Our Ref: FP/40/12/

Change of use from Offices (B1) to Residential use (C3) & three new dormer windows to replace existing

Church House 94 Felpham Road Felpham

Thank you for your internet representation made on 3rd April 2012 which has been recorded as **no objection** with the comments as follows:

BLOCK PLAN
Scale 1:500

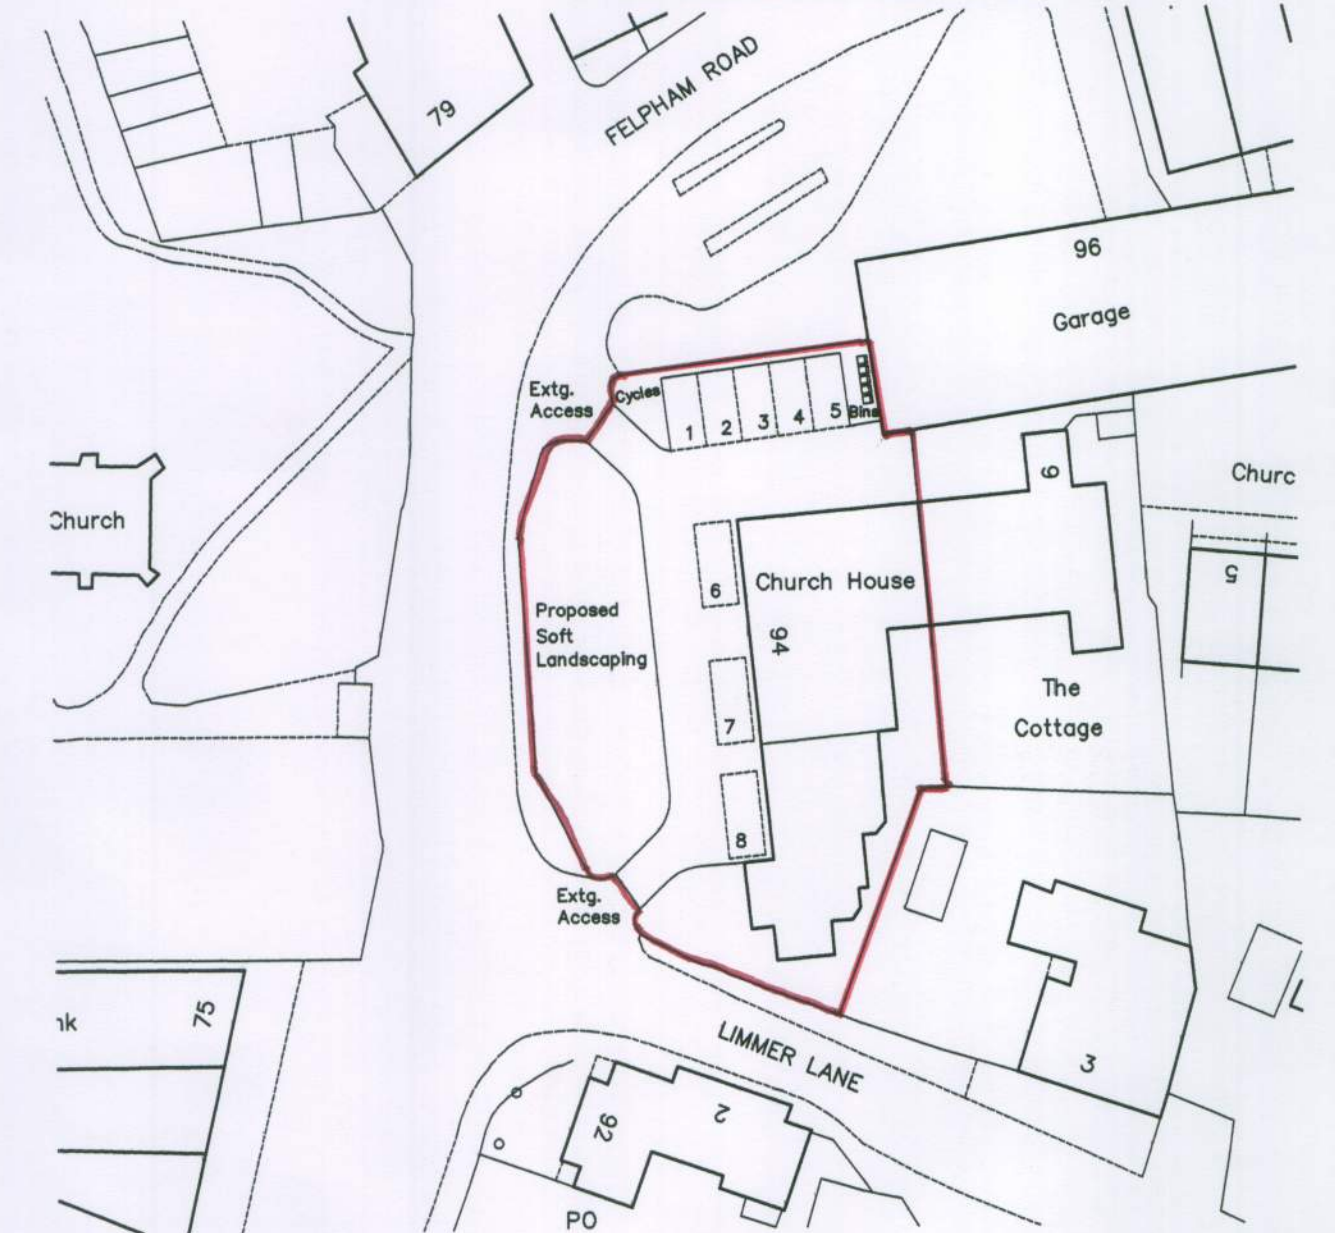
In fact there is a 4 foot right of way, running east/west, between the north facade of Church House to numbers 5 to 1 Church House Mews. The layout shown on the block plan does not appear to affect this right of way, but the developer should be aware.
